SITE PLAN

A PORTION OF THE NORTHWEST QUARTER OF SECTION 18,
TOWNSHIP 17 SOUTH, RANGE 67 WEST OF THE 6TH P.M.,
COUNTY OF EL PASO, STATE OF COLORADO

NOTICE: ACCORDING TO COLORADO LAW YOU MUST COMMENCE ANY LEGAL ACTION BASED UPON ANY DEFECT IN THIS SURVEY WITHIN THREE YEARS AFTER YOU FIRST DISCOVER SUCH DEFECT. IN NO EVENT, MAY ANY ACTION BASED UPON ANY DEFECT IN THIS SURVEY BE COMMENCED MORE THAN TEN YEARS FROM THE DATE OF THE CERTIFICATION SHOWN HEREON.			
PROJECT NO.	20-026	Drawn By:	TSM
		Checked By:	TSM
		Date:	04/11/20
		Sheet:	1 of 3

SITE PLAN AS REPLATTED
 A PORTION OF THE NORTHWEST QUARTER OF SECTION 18,
 TOWNSHIP 17 SOUTH, RANGE 67 WEST OF THE 6TH P.M.,
 COUNTY OF EL PASO, STATE OF COLORADO

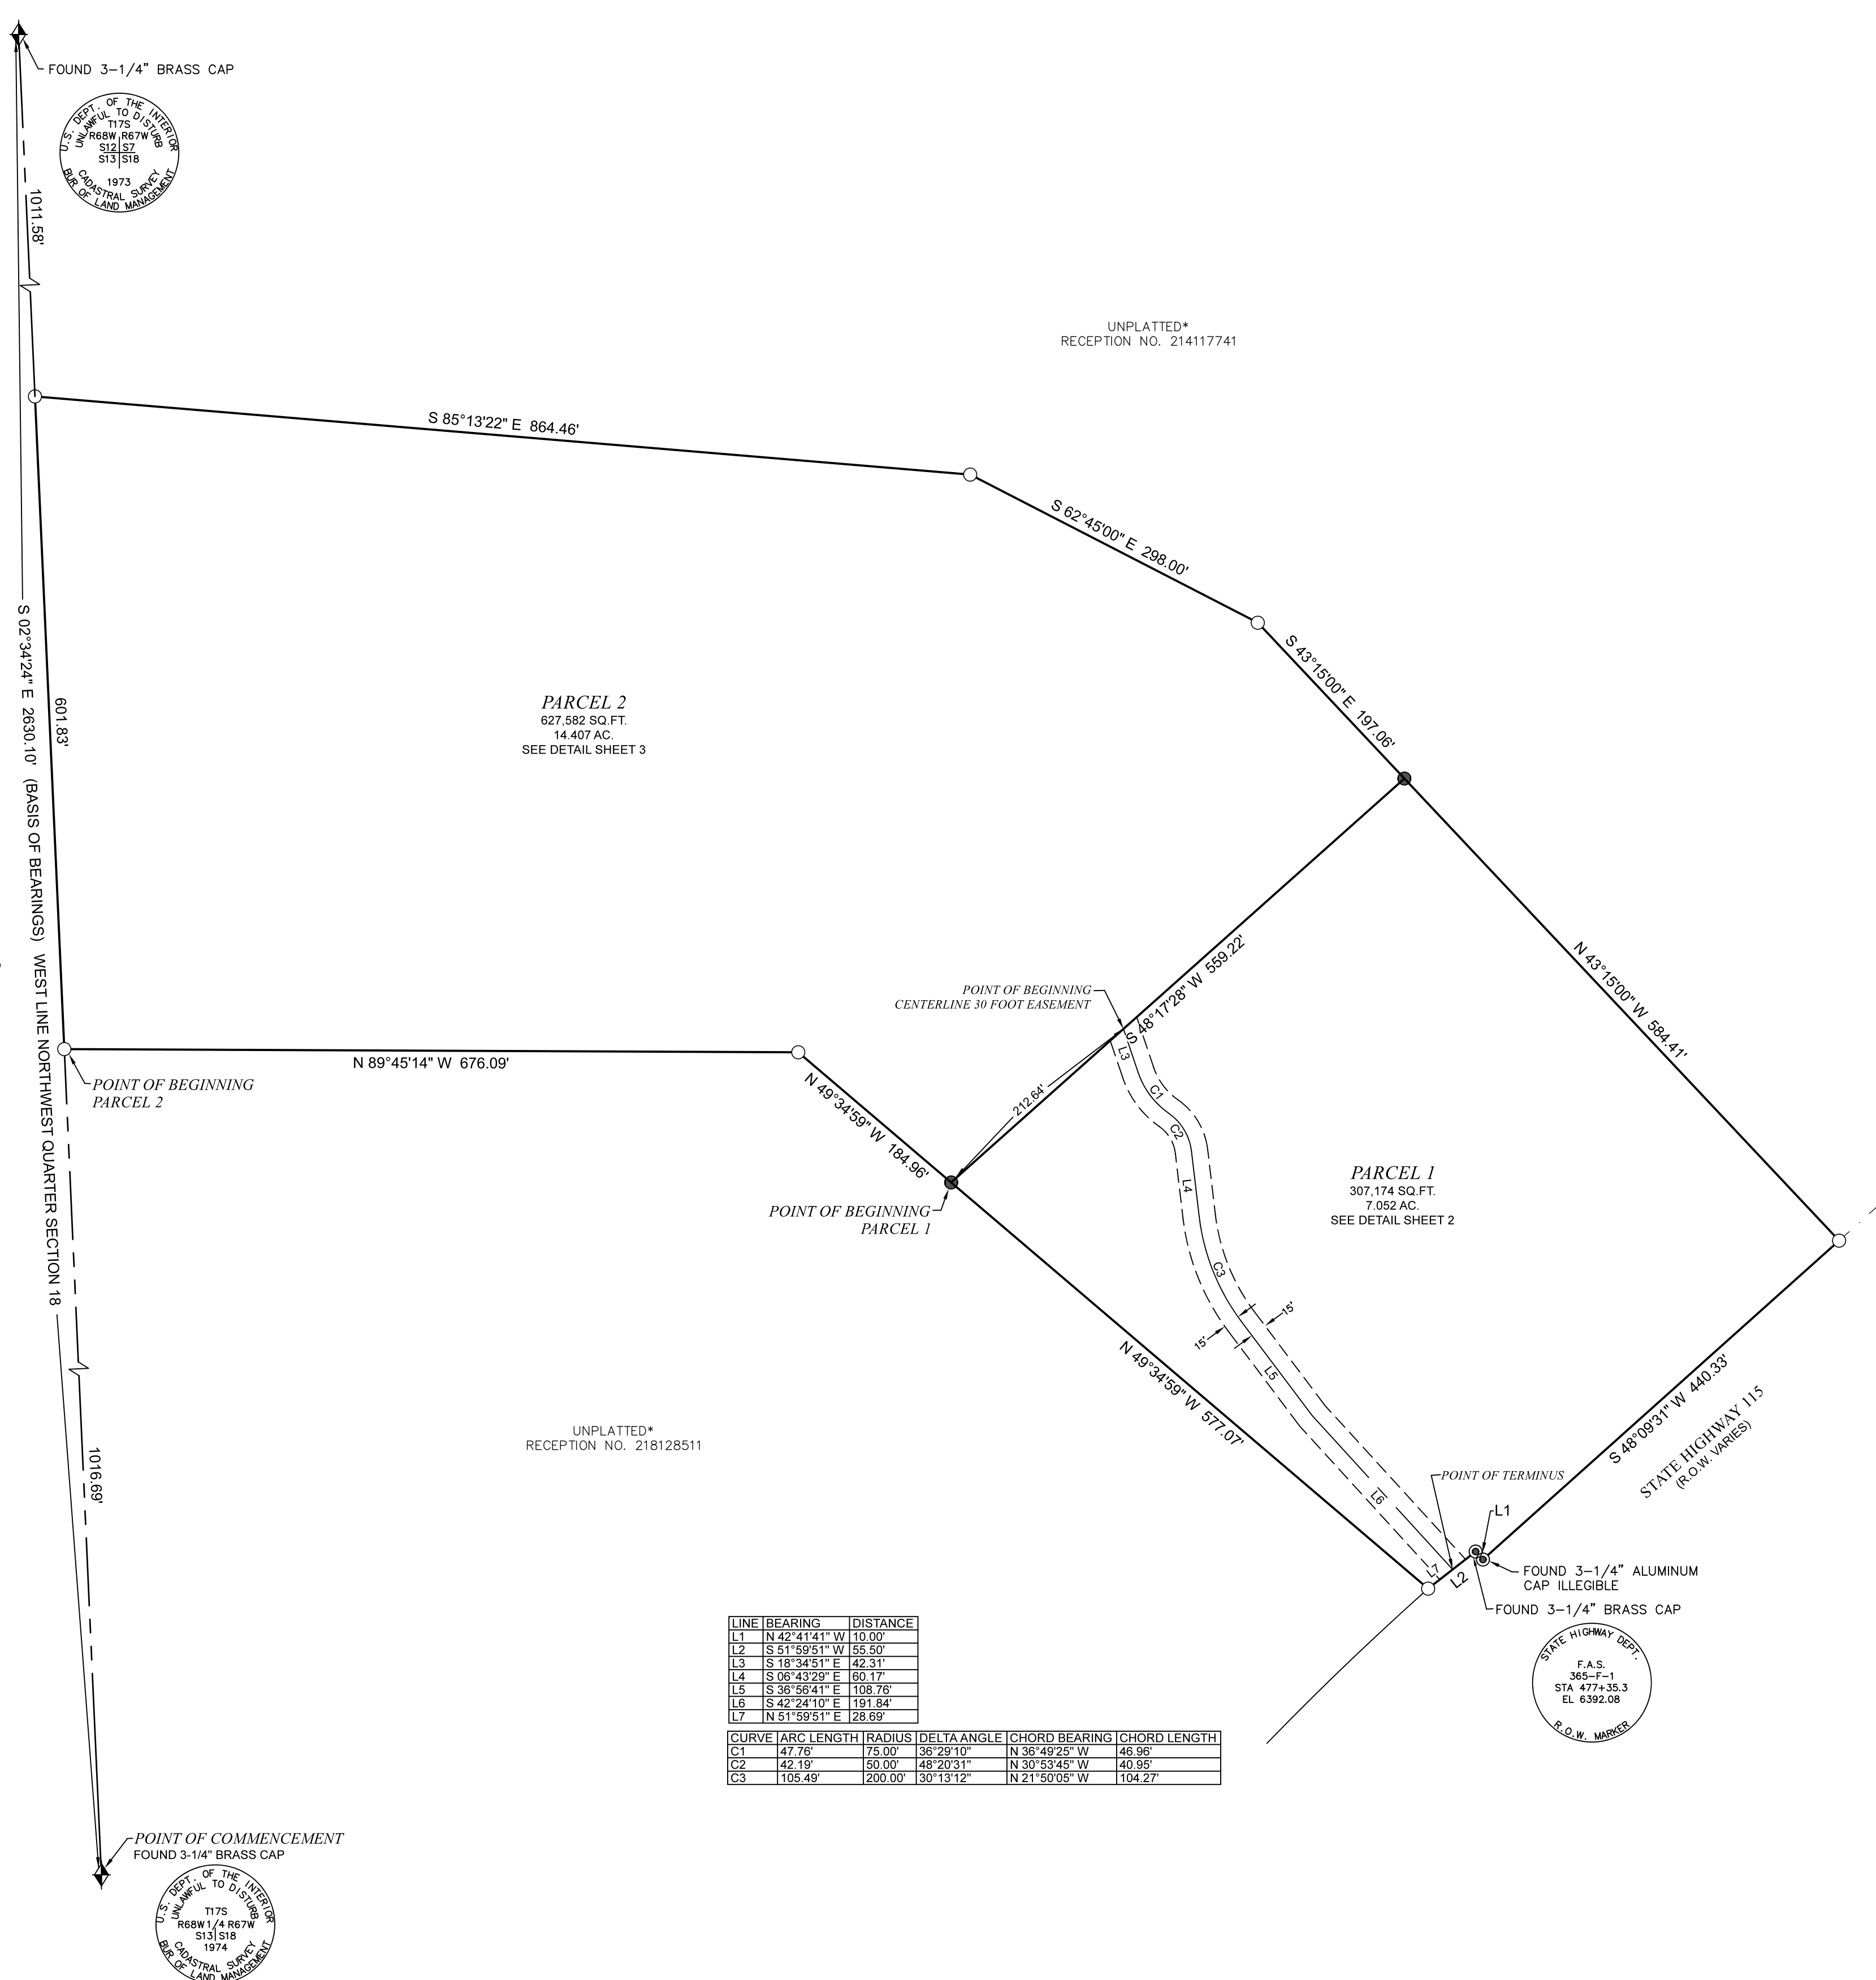
Please update to add following notes under note section:

"All property owners are responsible for maintaining proper storm water drainage in and through their property. Public drainage easements as specifically noted on the plat shall be maintained by the individual lot owners unless otherwise indicated. Structures, fences, materials or landscaping that could impede the flow of runoff shall not be placed in drainage easements."

"Mailboxes shall be installed in accordance with all El Paso County and United States Postal Service regulations."

"Individual lot purchasers are responsible for constructing driveways, including necessary drainage culverts from Road per Land Development Code Section 6.3.3.C.2 and 6.3.3.C.3. Due to their length, some of the driveways will need to be specifically approved by the (name of Fire District)."

Switch parcel number reference on the point of beginning callout to match the Legal Description.

SITE PLAN AS PLATTED

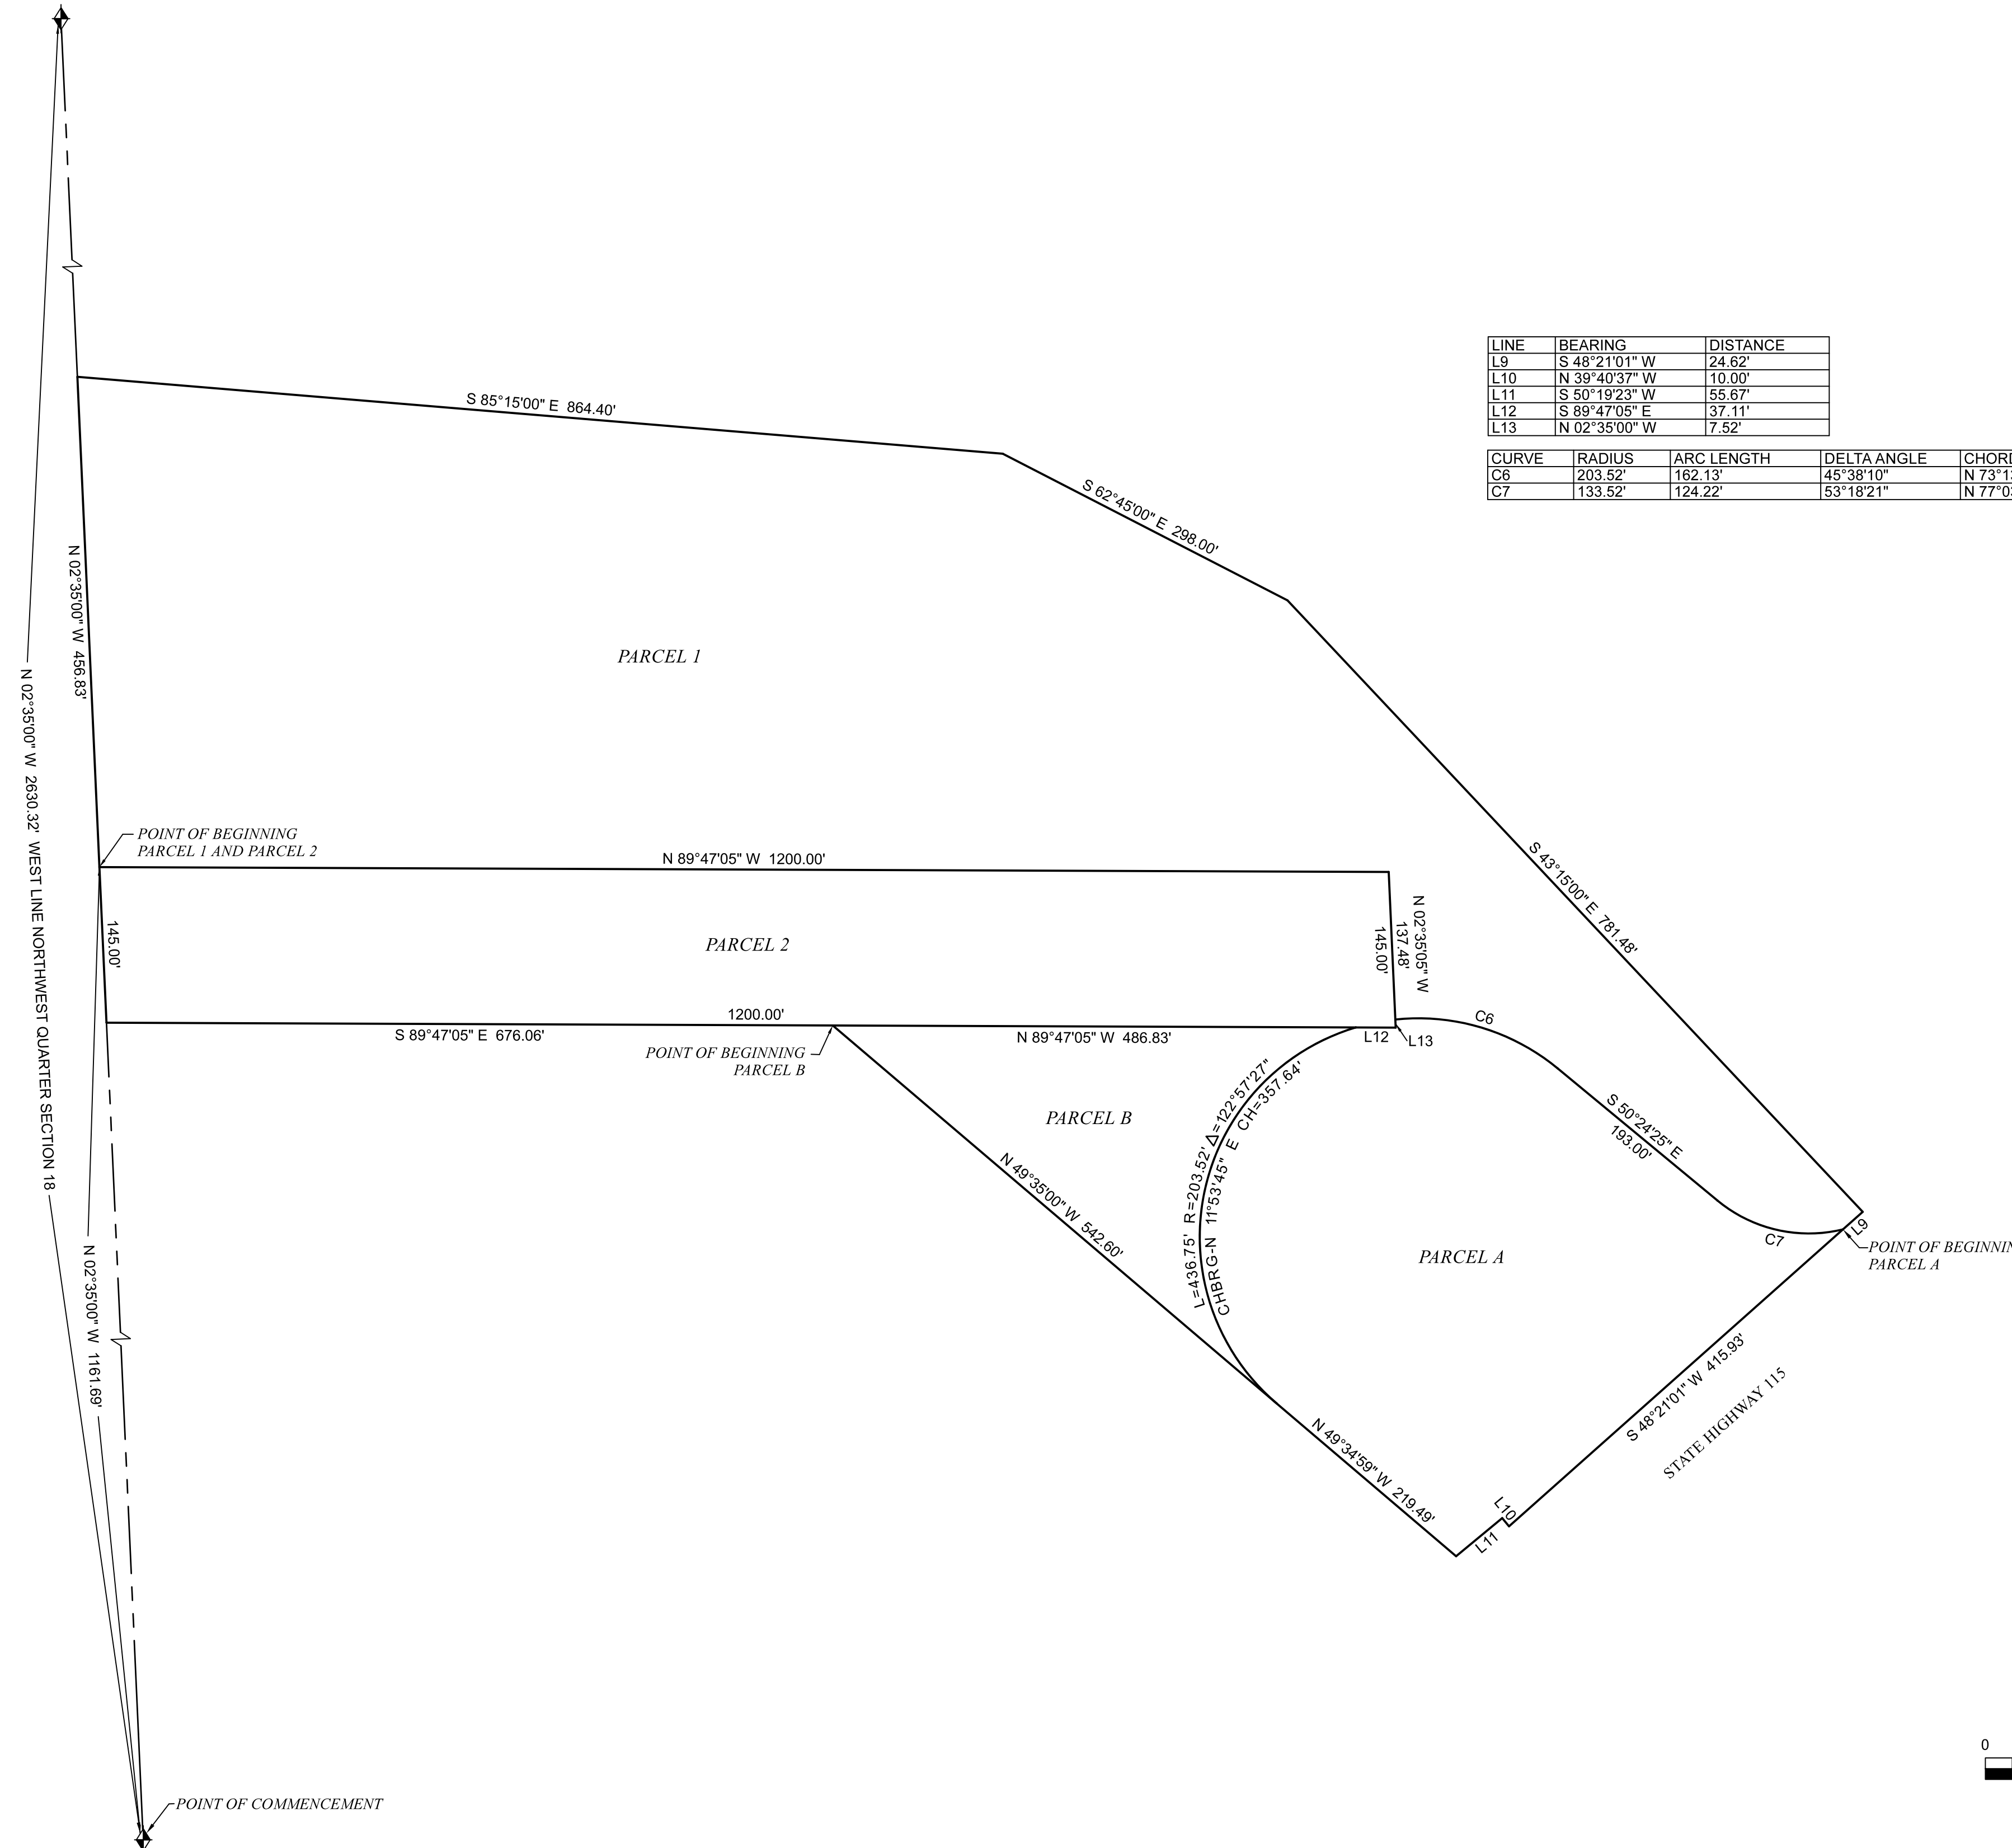
This exhibit should show the properties as existing and as proposed.
